Memorandum

To:	Planning	From:	Environmental Health
Officer:	Claire Booth	Officer:	Neil Martin
Reference:	3/2012/0525	Extension No:	3214
Date:	25th July 2012

Planning Application: 3/2012/0525
Location: Fellview Barn, Baygate, Bolton-by-Bowland
Development: Proposed machinery/tractor shed.

PROPOSED MACHINERY/TRACTOR SHED

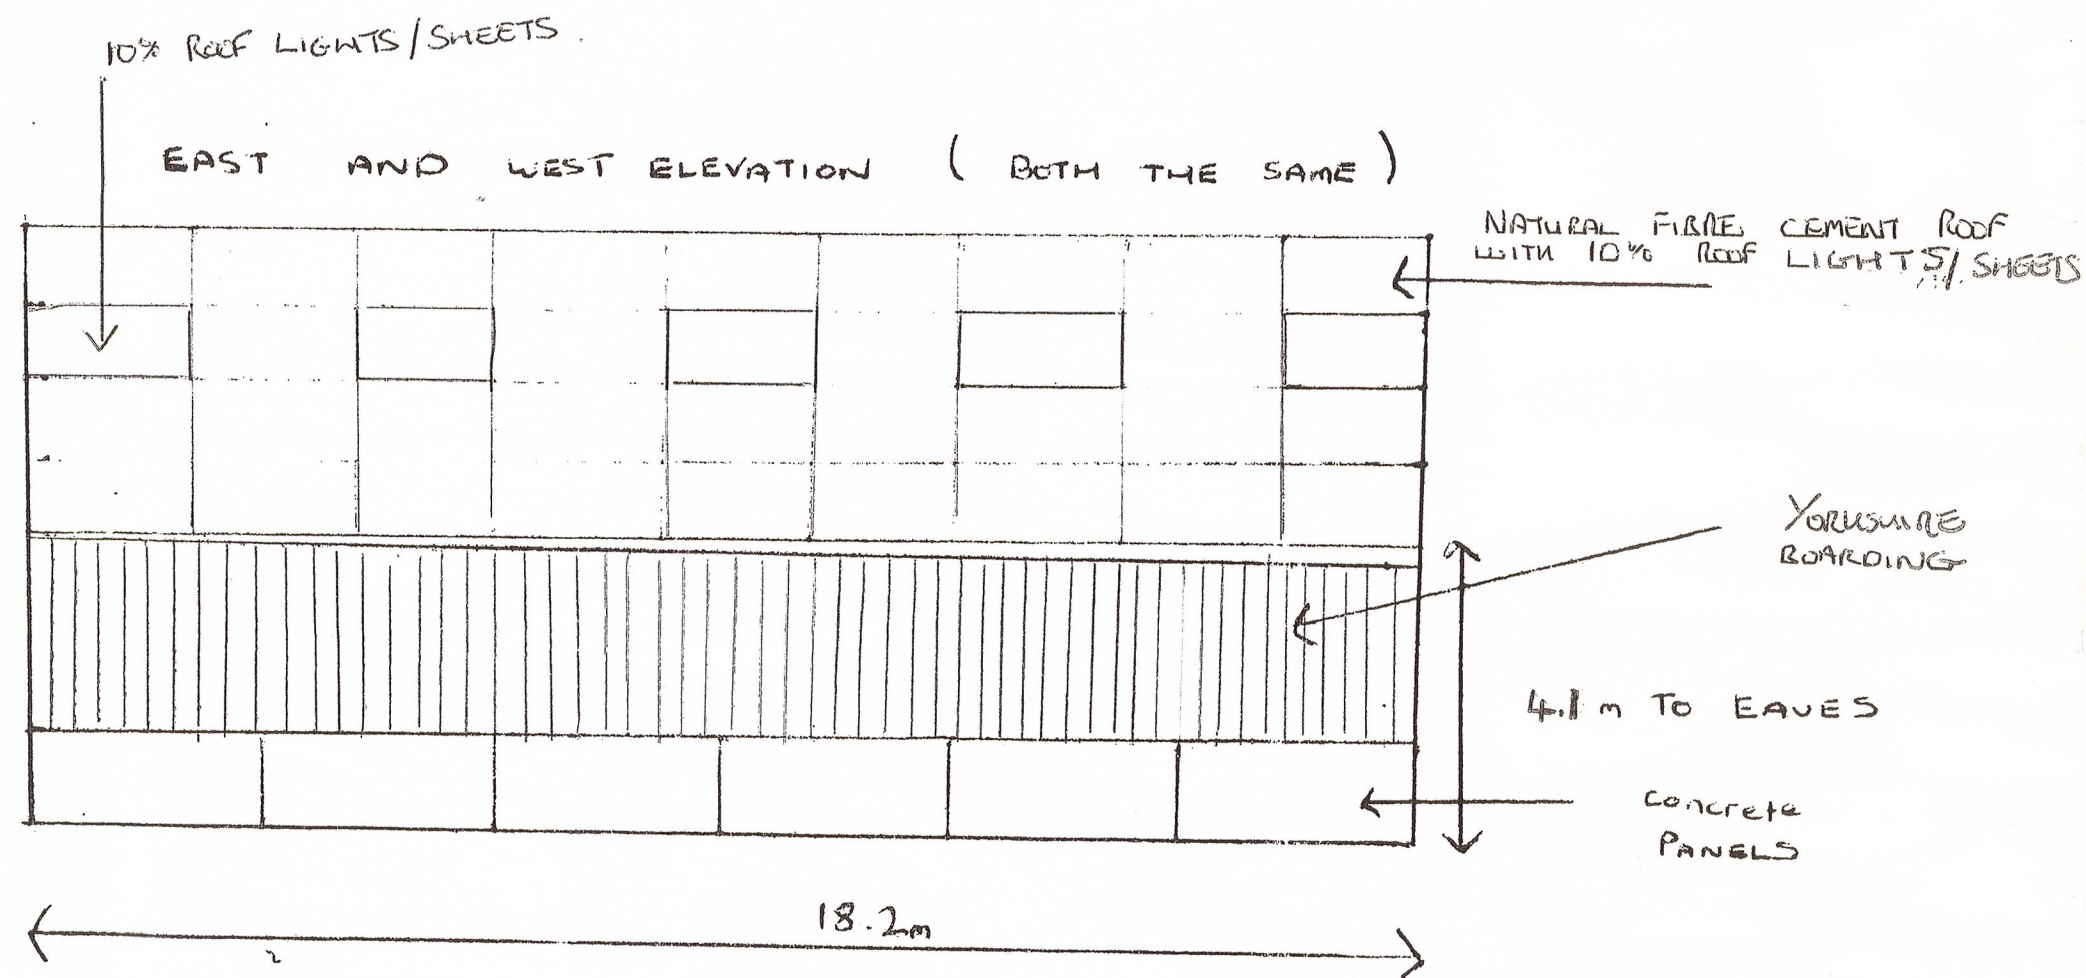
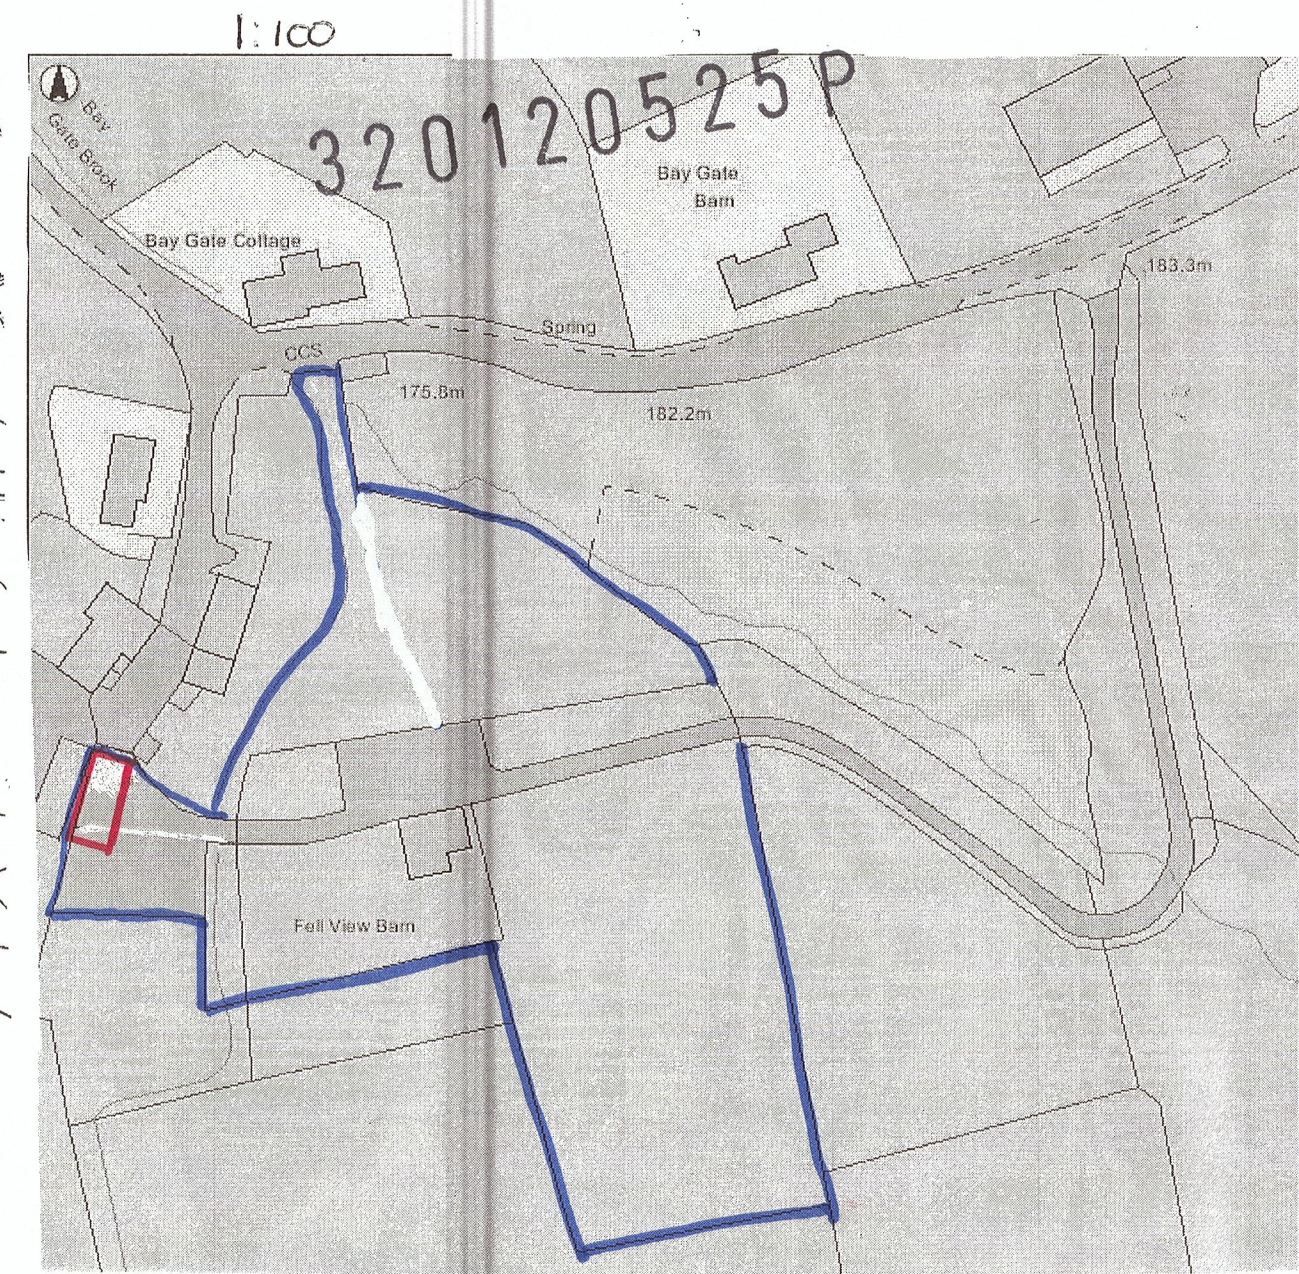
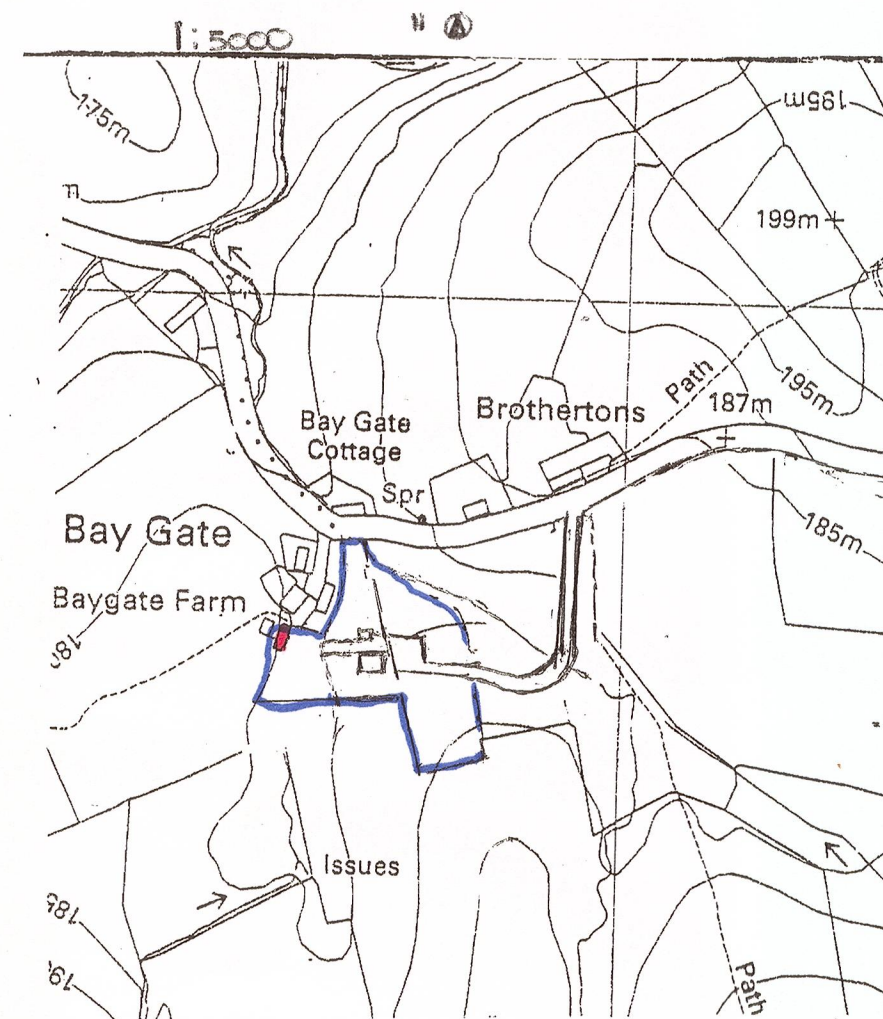
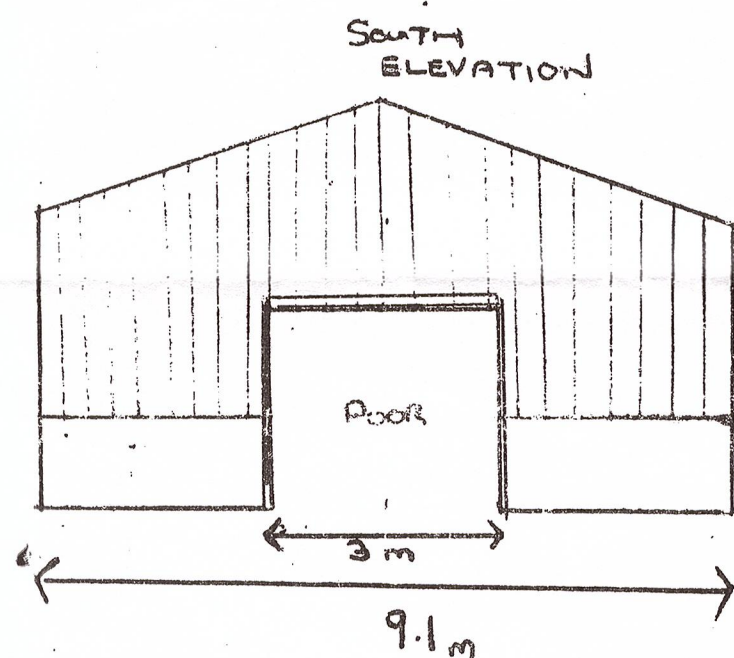
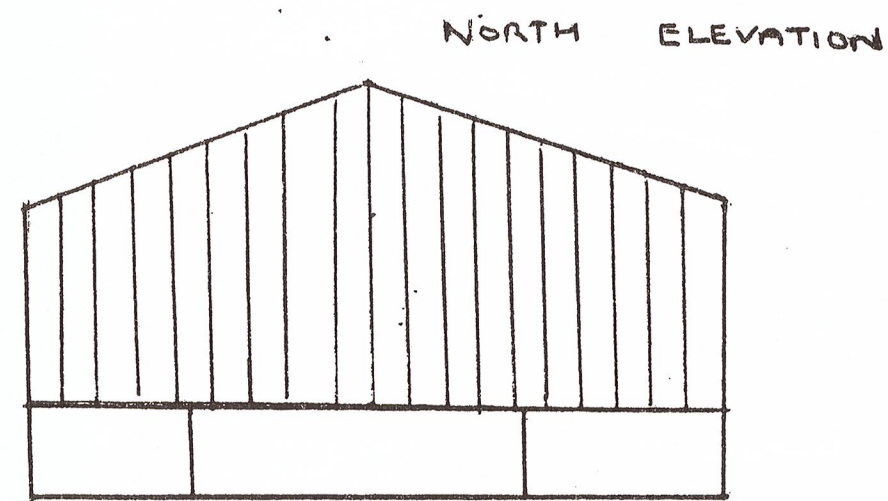
The proposed building and use has the potential to seriously affect the amenities of the area. Within 10m from the proposed building is located a barn which received planning permission for conversion into a domestic property in March 2012. As such any proposed development must ensure that it will not adversely affect this permitted development.

The proposed building is to be used as a machinery/tractor shed. And is of a relatively basic design. The noise levels produced by a tractor, and possibly the other machinery is fairly high and as such insufficient attenuation is provided between the proposed building and the converted barn to prevent adverse noise levels affecting the residents of the converted barn. Particularly given the long hours and early morning s in which farms operate and will undoubtedly use the tractor and other machinery.

A more appropriate location for the building would be further away from this boundary adjacent to the farms other agricultural buildings.

There is also an issue regarding any potential pollution in the future from maintenance work on equipment or defective equipment through the release of oil's etc. Full details of the drainage, catchment and interceptors to be installed would be required prior to any commencement of works.
